# PLANNING CONSULTATION REPLY

**APPLICATION: Darley Cliff Hall, Kingwell Road, Worsbrough, S70 4AG.**

**2 0 2 1 1 5 6 7**

Darley Cliffe Hall, Rear Garden, Tree Removal Plan

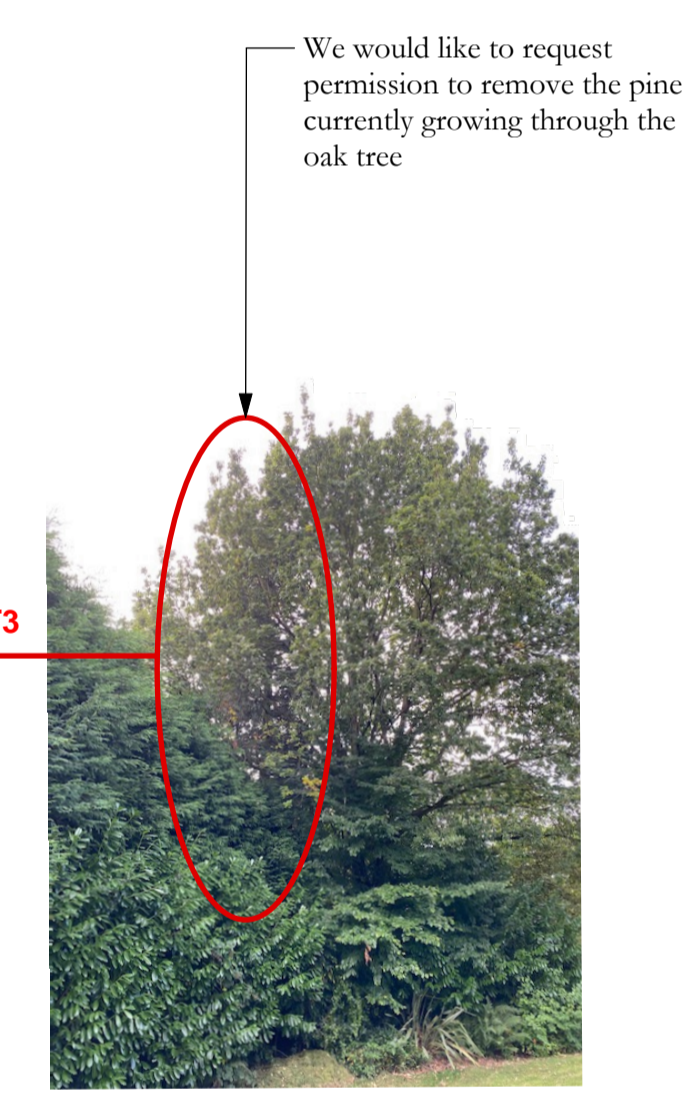
The application is to remove and replace Holly (T1), Cherry (T2), Pine (T3), Silver Lime (T4) and Copper Beech (T5) and replace with 26 new native deciduous trees.

The Pine tree is a poor specimen which is having a detrimental effect on the Oak which it is growing into. The Oak is a far superior specimen and as such the removal of this tree to enable the continued development of the Oak is considered sensible and appropriate management to keep one good specimen rather than ending with two poor specimens due to the competition between them.

The Silver Lime has a major crack in the main union. This tree is therefore hazardous and needs to be removed as soon as possible given the size of the tree and threat to both the applicants and neighbouring properties.

The Copper Beech is a large mature high value specimen. The reason given for removal is due to the damage to the listed wall. The documents provided are very basic with the tree survey simply asserting that the tree requires removal due to the damage to the wall. This is clearly unacceptable and I fail to see what the author aimed to achieve by simply making a comment and then not detailing the rationale. Regrettably this document is of no use in making the decision on this tree. This should be referred back to the consultant really for their reasoning on their comment to be provided. Having looked at the tree however, the reason is evident and entirely obvious (which raises the question of why this was not detailed in the discussion) and I have no desire to waste the applicant time in pursuing this with the consultant.

The trees will require replacing and plans detailing this have been provided (Drawing numbers 4R1 Rev A.1 Tree Removal and Replacement Planting Scheme Rear Garden received 4<sup>th</sup> February 2022 and 4R1 Rev A.1 Tree Removal and Replacement Planting Scheme Front Garden received 4<sup>th</sup> February 2022) these are comprehensive and go well beyond what is required for direct replacement of the trees to be removed.

I can confirm with regret that the removal and replacement of the trees subject to this application are required and/or appropriate and as such there is no objection from an arboricultural perspective.
